DELEGATED DECISION

Item No.	Report of the Head of Development Management and Building Control	
Address:	23 SKIPTON DRIVE HAYES	
Development:	Conversion of a single dwellinghouse into 1 x 2-bed 3 person flat and 1 x 2-bed 4 person flat, to include installation of a vehicle crossover, and associated associated parking, waste and cycle spaces.	
LBH Ref Nos:	9462/APP/2024/3224	
Drawing Nos:	Location plan 121B 120A 100D 112B Design and Access Statement Planning Statement	
Date Plans received:	09-12-24	Date(s) of Amendments(s):
Date Application valid	09-12-24

TITLE:
PROPOSED FLOOR PLANS

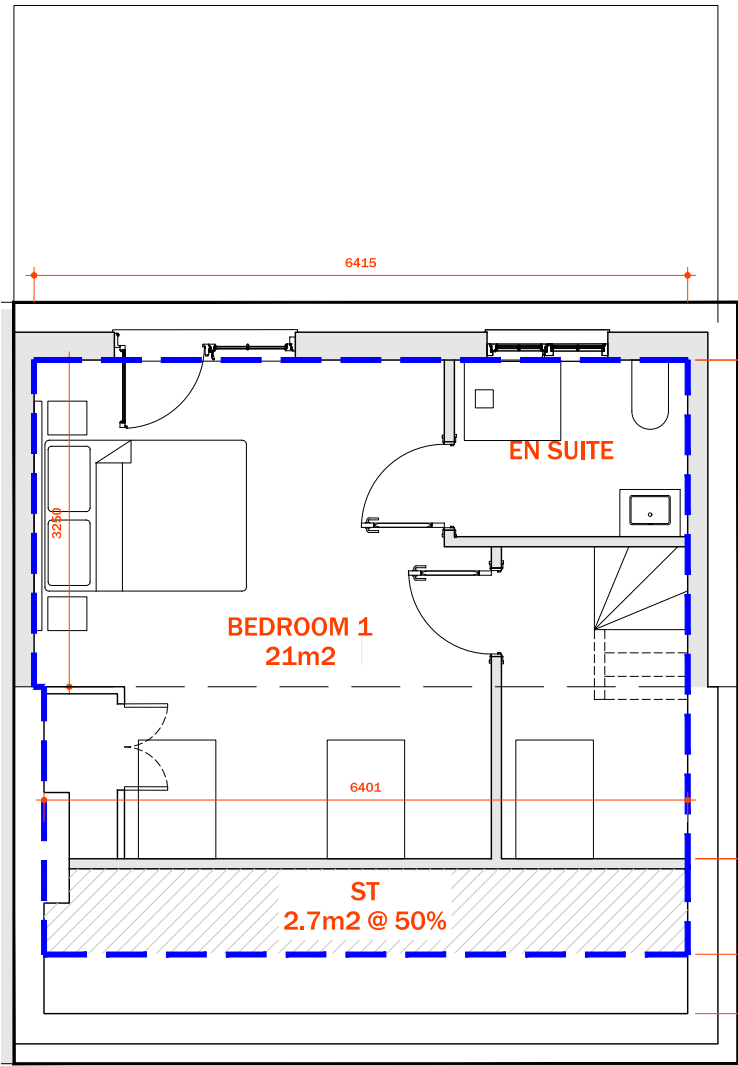
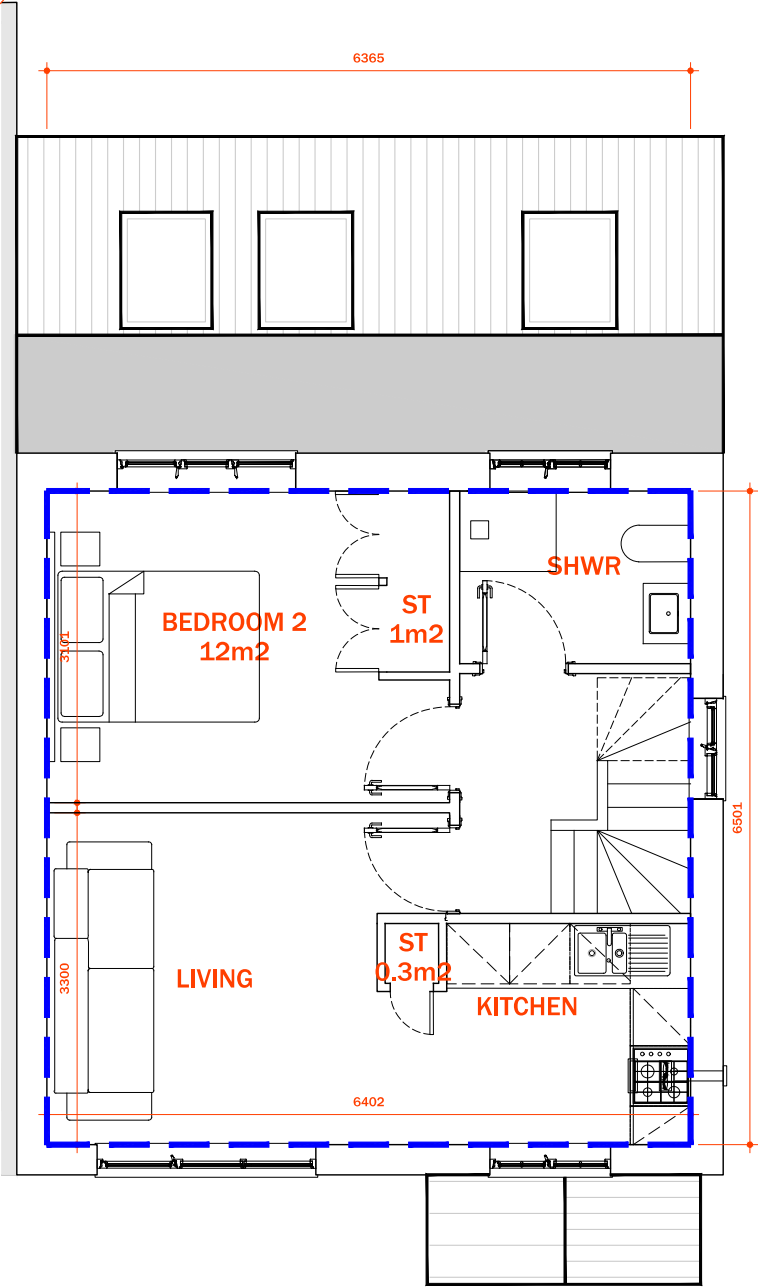
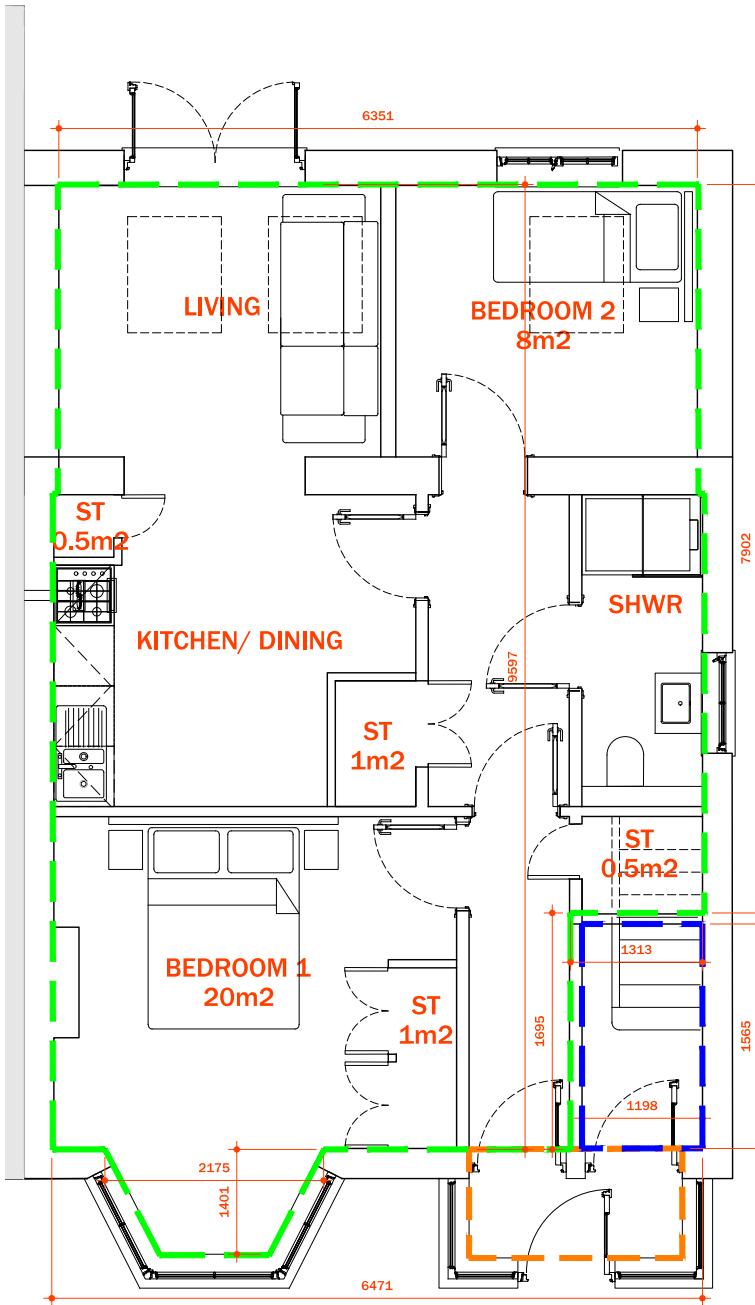
Due to their cramped and substandard internal floor layout, both of the proposed flats would provide their future residents with poor and unacceptable living accommodation to the detriment of their amenities. The proposal would therefore be contrary to Policy DMHB 16 of the Hillingdon Local Plan: Part 2 - Development Management Policies (2020), Policy D6 of the London Plan (2021) and paragraph 135 (f) of the National Planning Policy Framework (2024).

- A one storey dwelling with 2 bedroom, 3 person occupancy should provide a GIA of at least 61 square metres;
- A two storey dwelling with 2 bedroom, 4 person occupancy should provide a GIA of at least 81 square metres;

The Policy also states '3) A one bedspace single bedroom must have a floor area of at least 7.5 sq.m. and be at least 2.15m wide'

The proposed development would provide a 2bed 3person flat (at ground floor) which is 59m² and a 2bed 4person flat (at first floor) which is 76m². Both flats would fail to meet the floorspace requirements outlined above and subsequently would provide future residents with poor and substandard living accommodation. The development is therefore considered to provide an unacceptable standard of amenity for its future residents and the development is contrary to policy D6 of the London Plan (2021), Policy DMHB 18 of the Hillingdon Local Plan: Part 2 - Development Management Policies (2020) and paragraph 135 f) of the NPPF (2024), in this respect.
